Re: Planning Application 20/1035

Address: 135 Henthorn Road Clitheroe BB7 2QF

Description: Proposed two storey side extension and rear extension.

Simon Hardie
Highways Development Control
Lancashire County Council

PROPOSED SITE PLAN SCALE 1:100

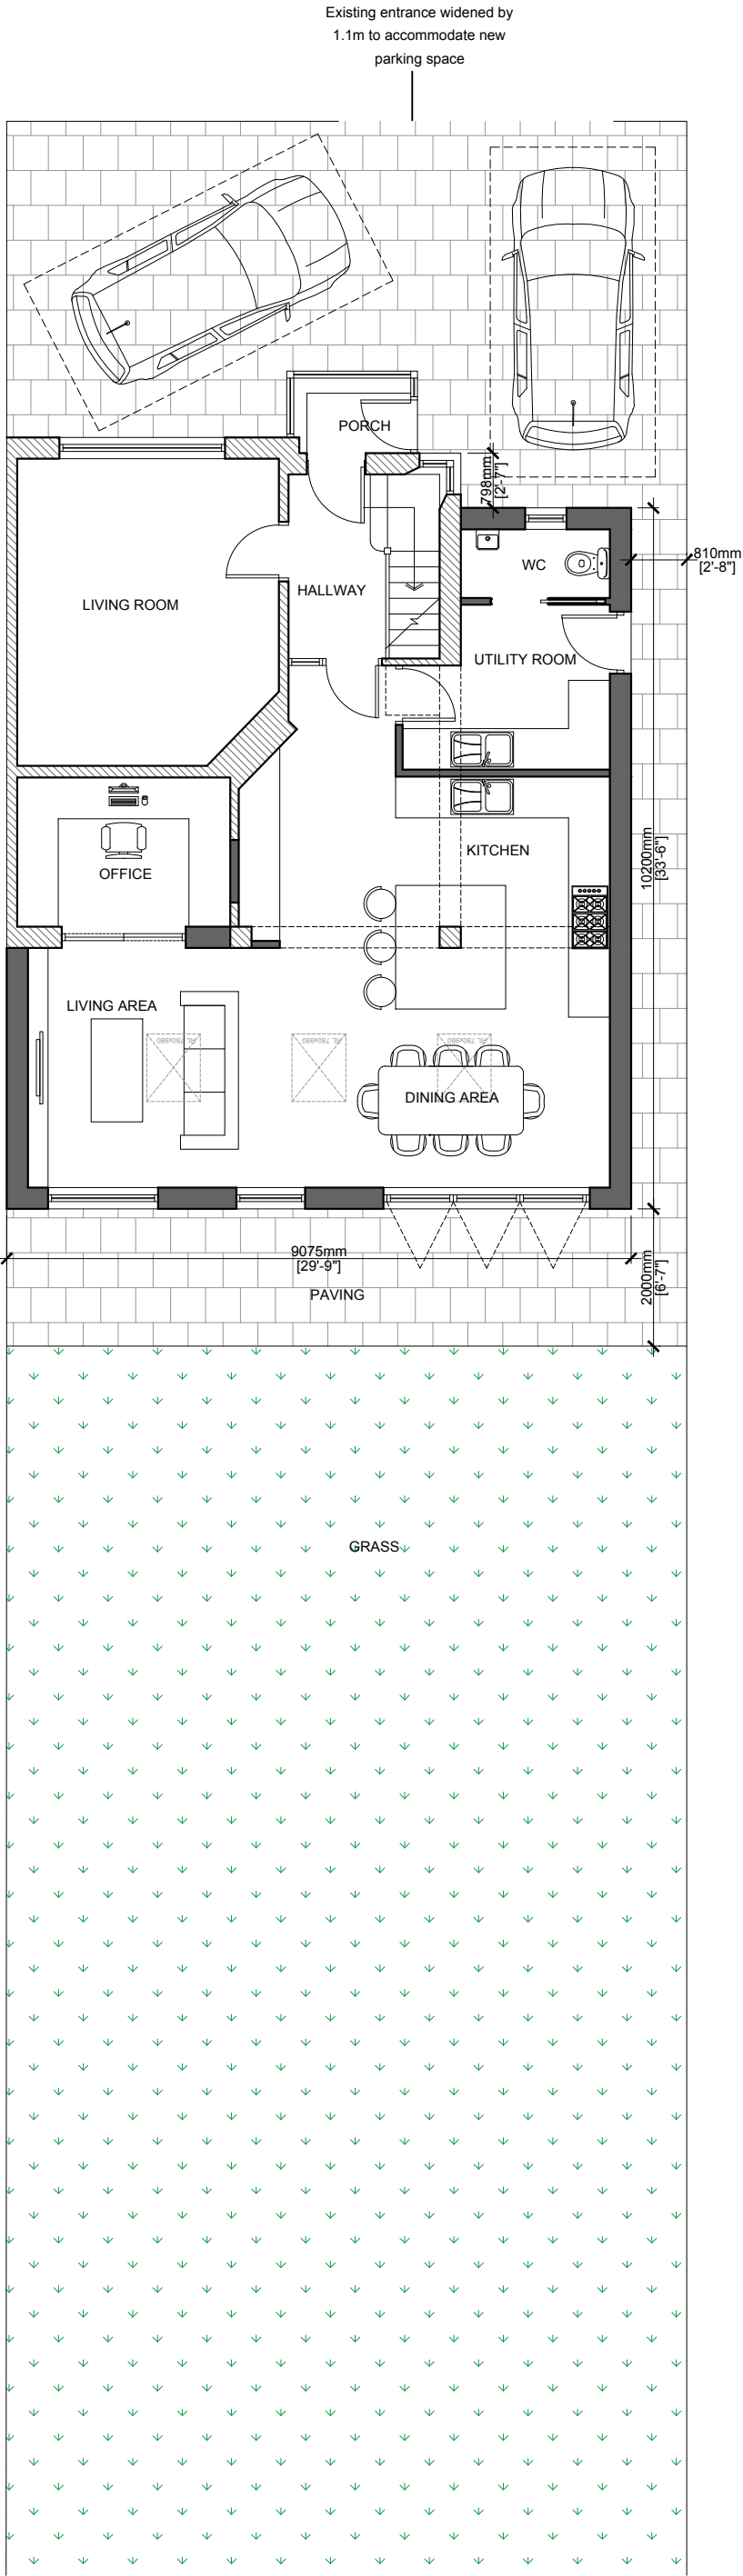
There are however concerns regarding the width of the access from the Highway it is not apparent that the access will be usable by either vehicle independently of each other. In order to aid the access from the highway, it is felt that the aperture should be further widened in both directions.

In order to progress the application we would look for a further plan showing swept path analysis showing that both vehicles can access the driveway independently.

This may require the widening of the existing dropped crossing. (See Notes Below)
